Application No: FP/175/20/HH
Site Address: 23 Thirlmere Way Felpham PO22 8NQ
Description of works: Single storey side & two-storey rear extension.

Thank you for your internet representation made on 19th October 2020 which has been recorded as an objection with the comments as follows:

Drawing Title:
SITE PLAN

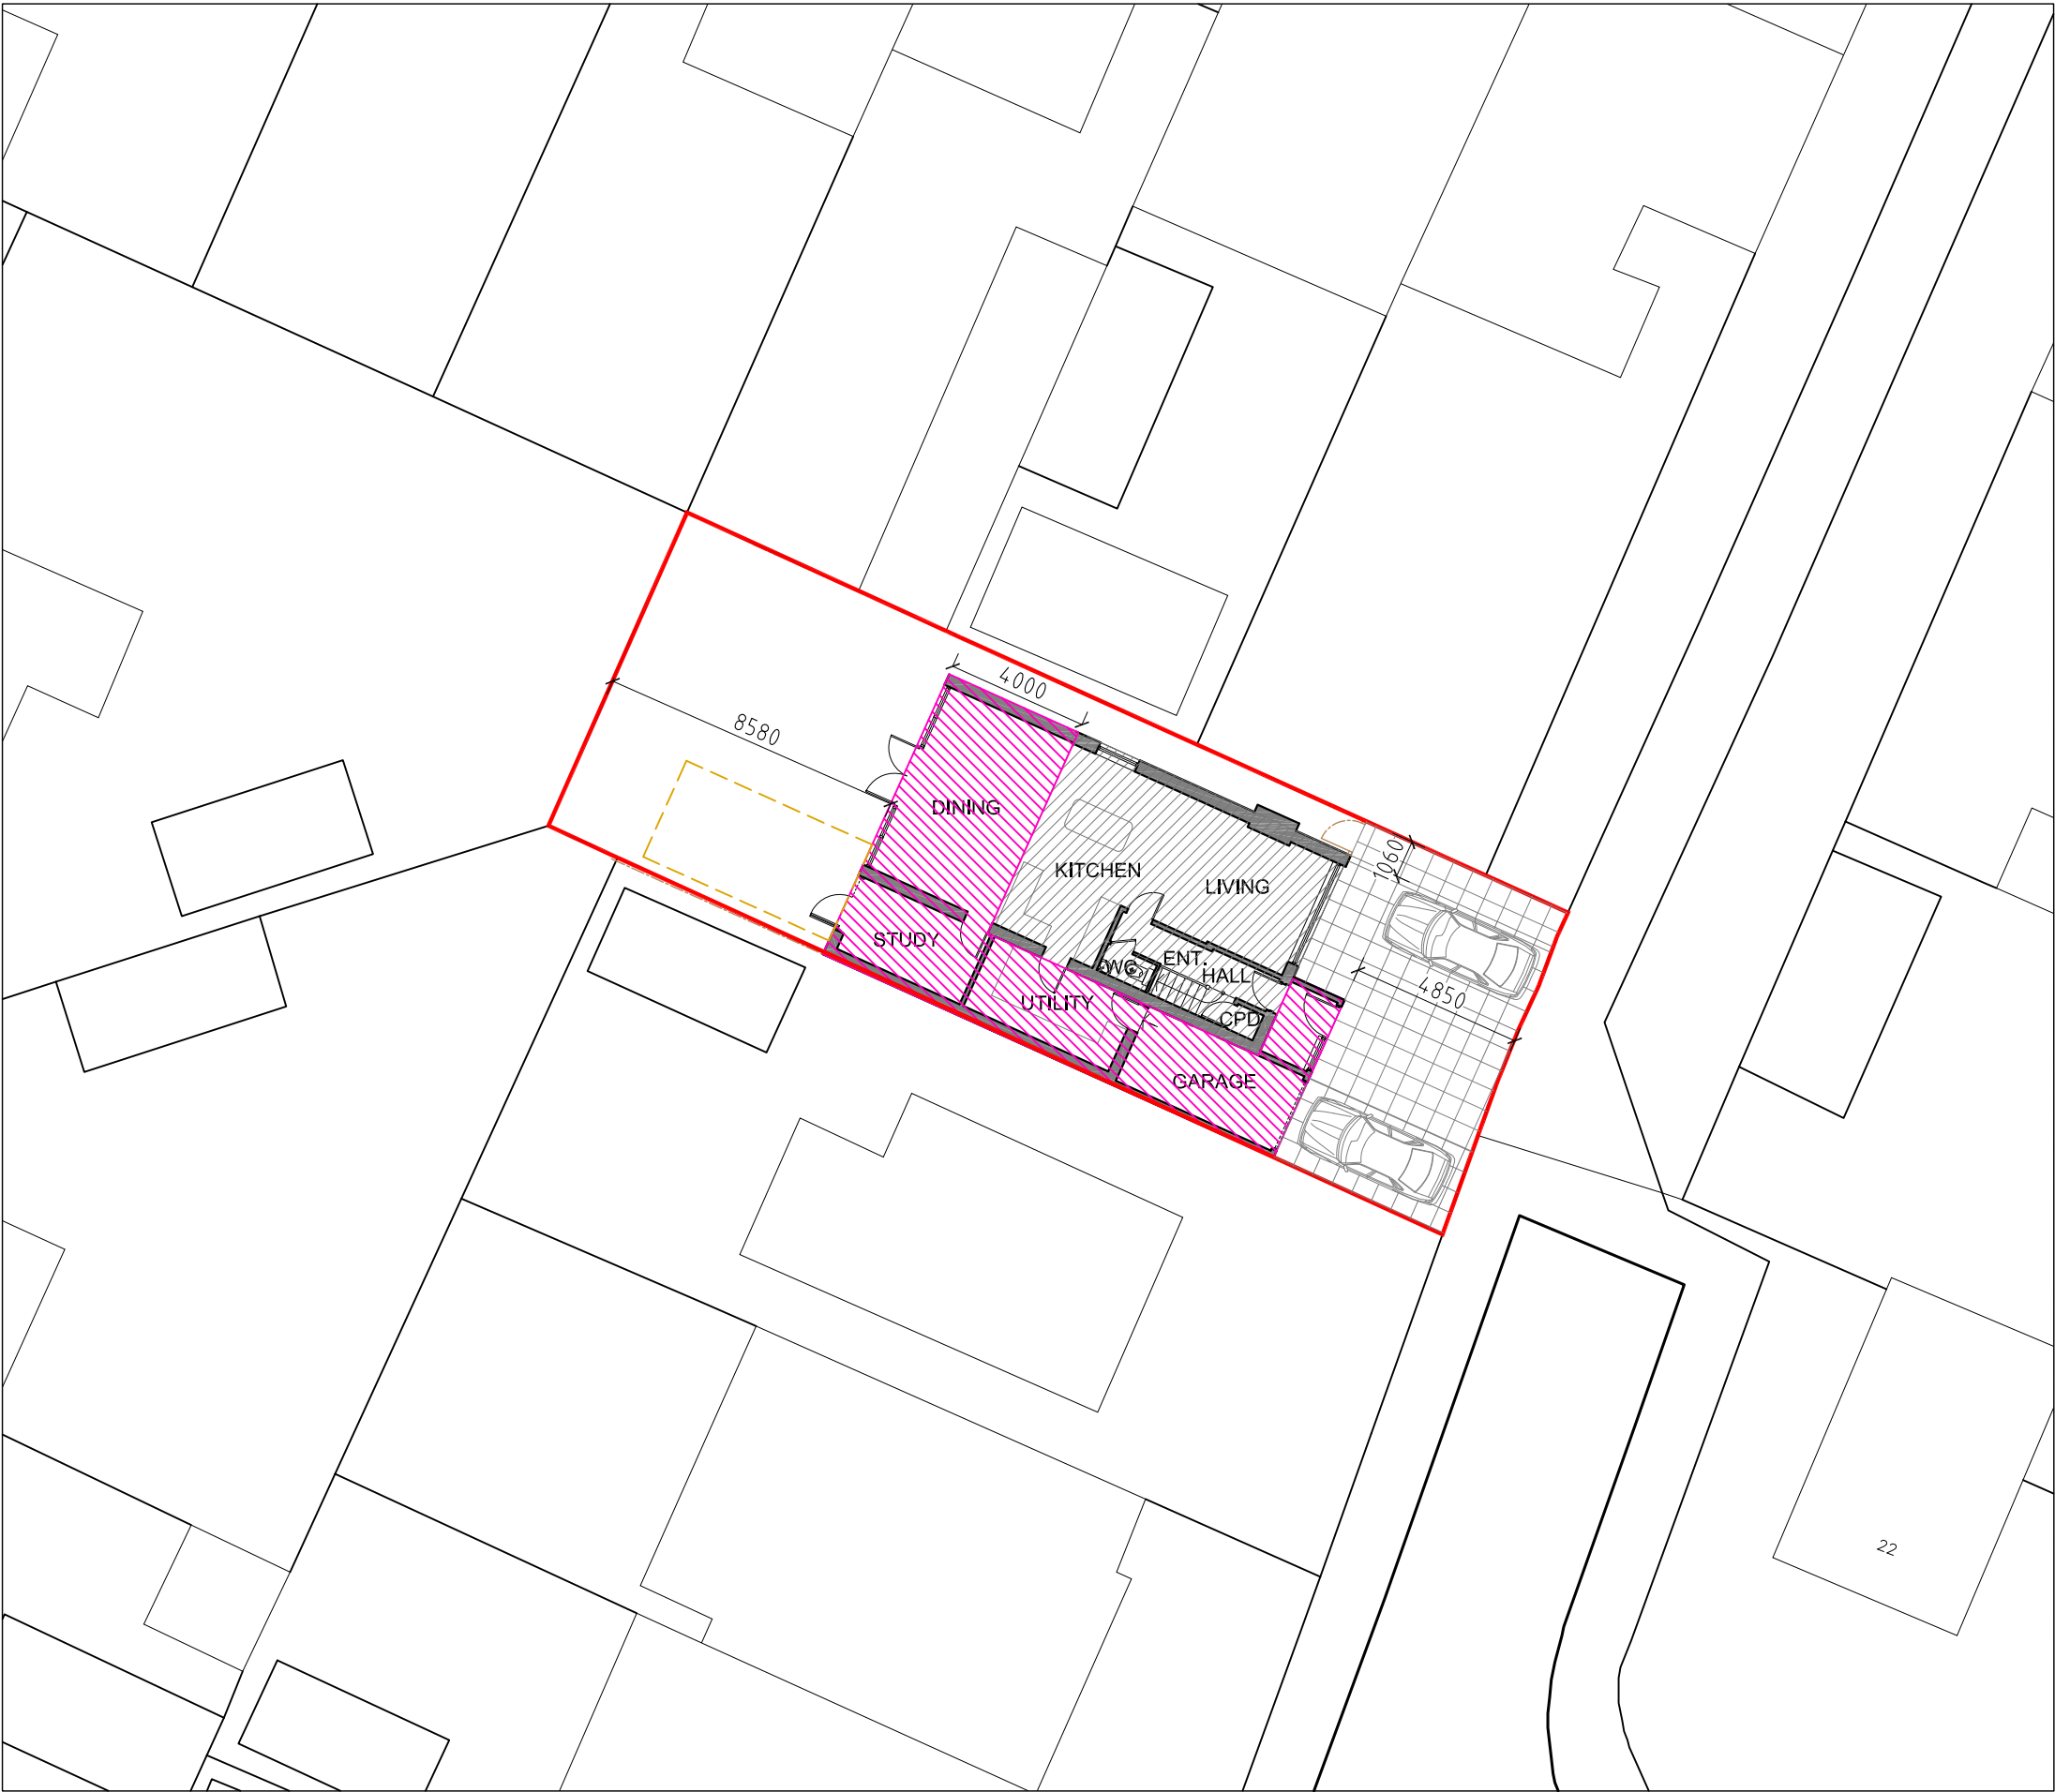
The property is situated at the end of a cul-de-sac and parking is already an issue causing contention between the neighbours. The new proposed garage is not full width, limiting its use as a garage and therefore will only leave parking for 2 cars. Cars parked in the turning circle means large construction vehicles will have to reverse up the full length of the road.

Since the new housing estate to the north has been built, the public footpath adjacent to the property has become much busier than was originally intended; pedestrians, cyclist, parents with prams and mobility scooters now often have to negotiate their way around parked vehicles at the entrance to the footpath. The additional parking to the front of the property as shown on the plan means vehicles from this property will be reversing over the footpath entrance to gain access to the road.

The plans show the occupier wishes to build on top of 2 drains on their driveway. These drains are the only access to the shared sewers for 4 properties in the road. The drains have become blocked several times in the past and Southern Water have had to be contacted to investigate with cameras. The drains could become damaged by the footings for the new building.

Drawing Title:
PROPOSED PLANS AND ELEVATIONS

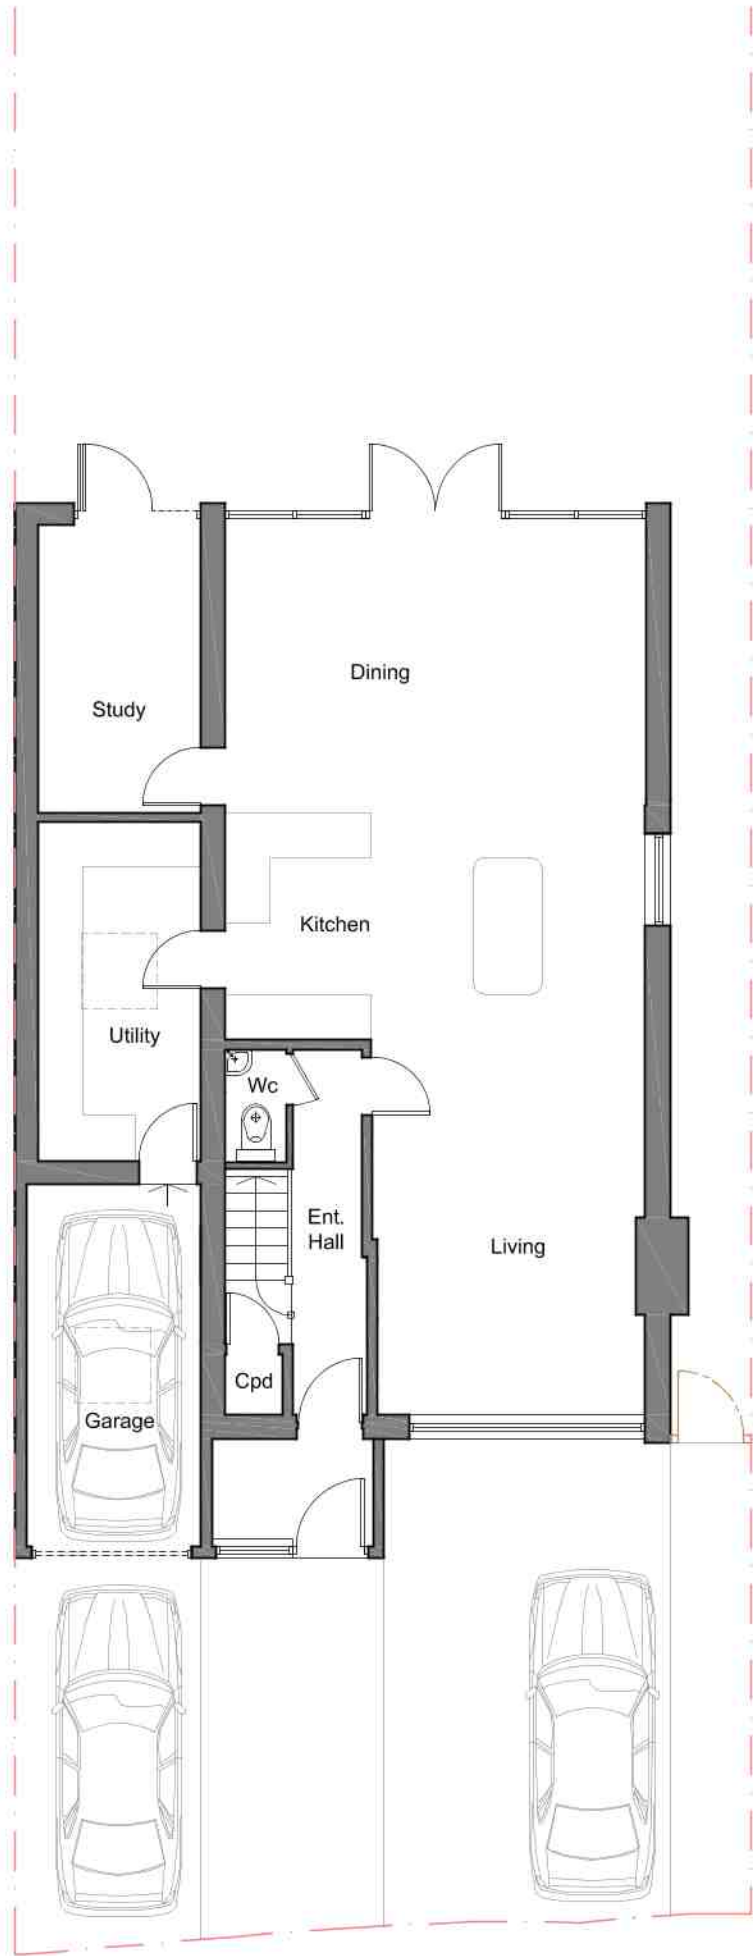
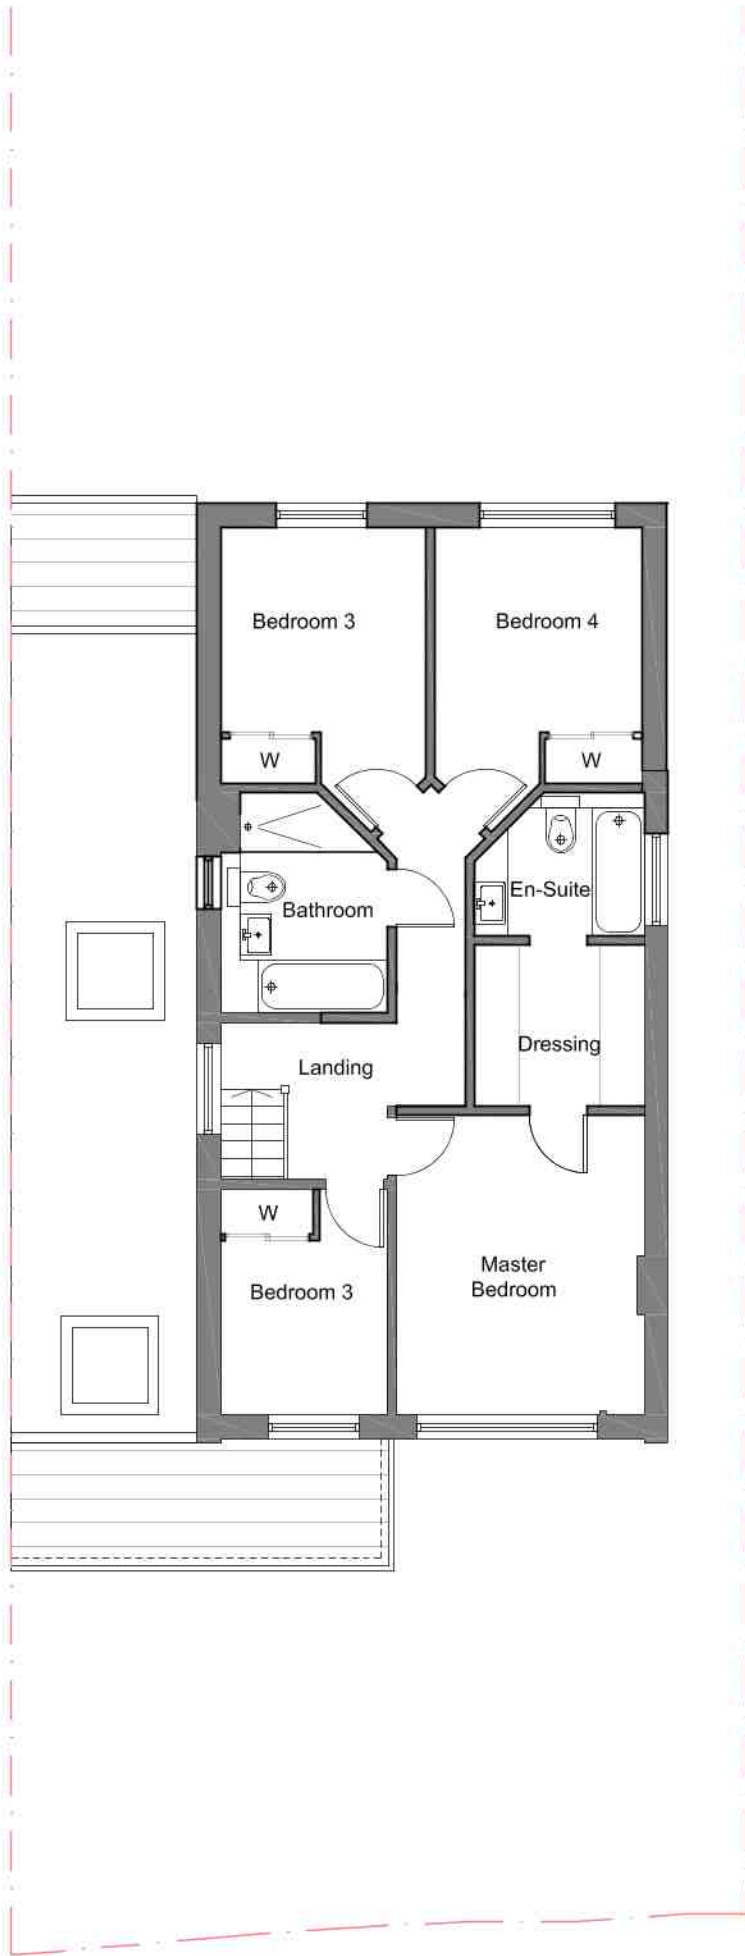
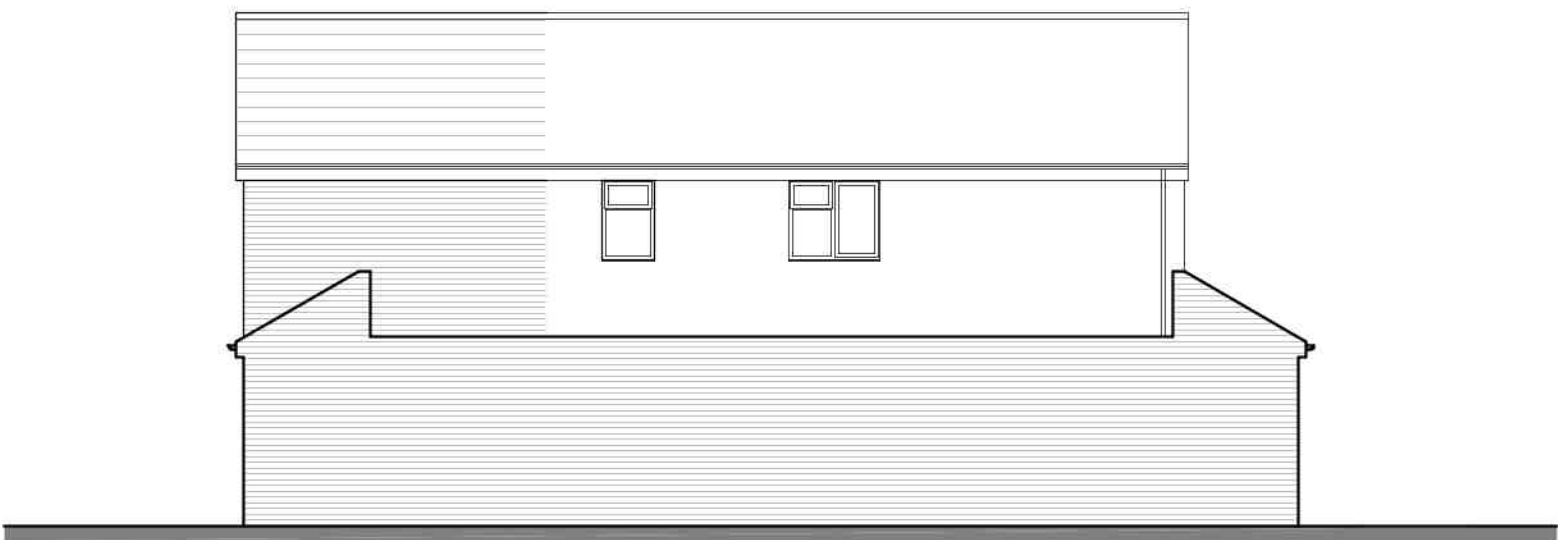
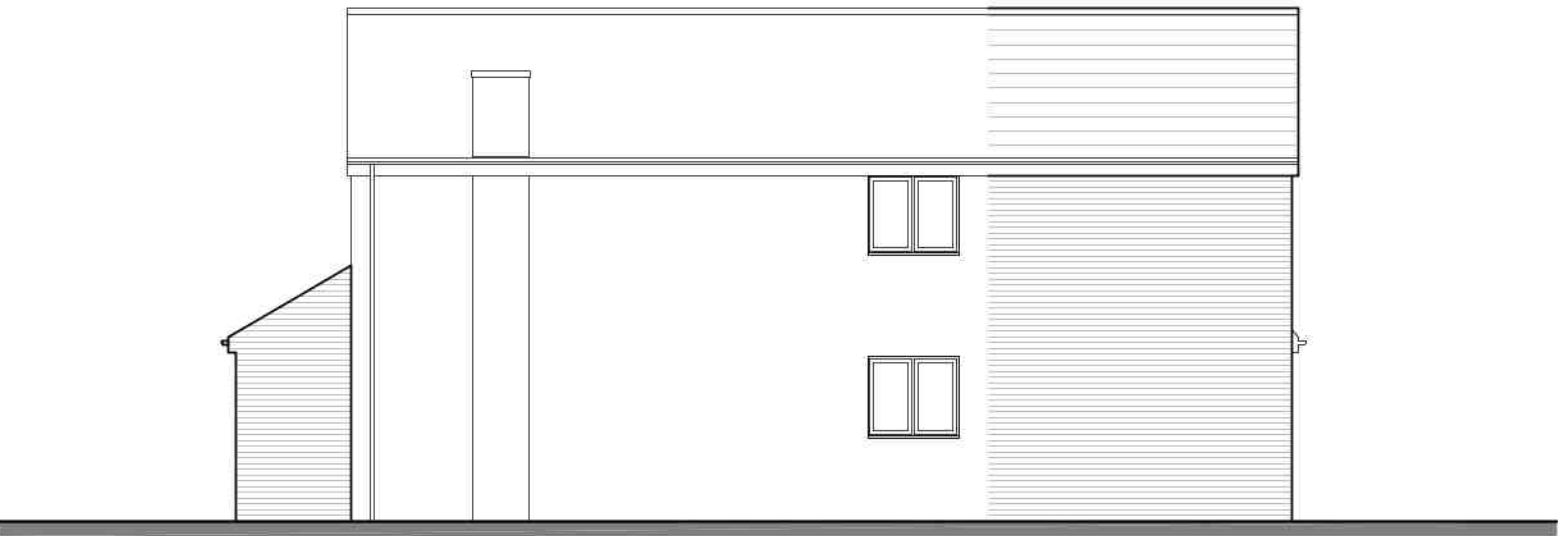
The plans propose to build out 4m from the existing property which will overshadow our house significantly and is not in keeping with the style/size of the houses in this area. The proposed additional first floor window will overlook our garden therefore affecting our privacy.

The plans show that the single storey building will be constructed right up to our boundary line which less than 3m away from the side of our house. The current 6ft fences will need to be removed in order to do so which will give us no privacy and the noise/dust from the build will significantly impact our everyday lives.
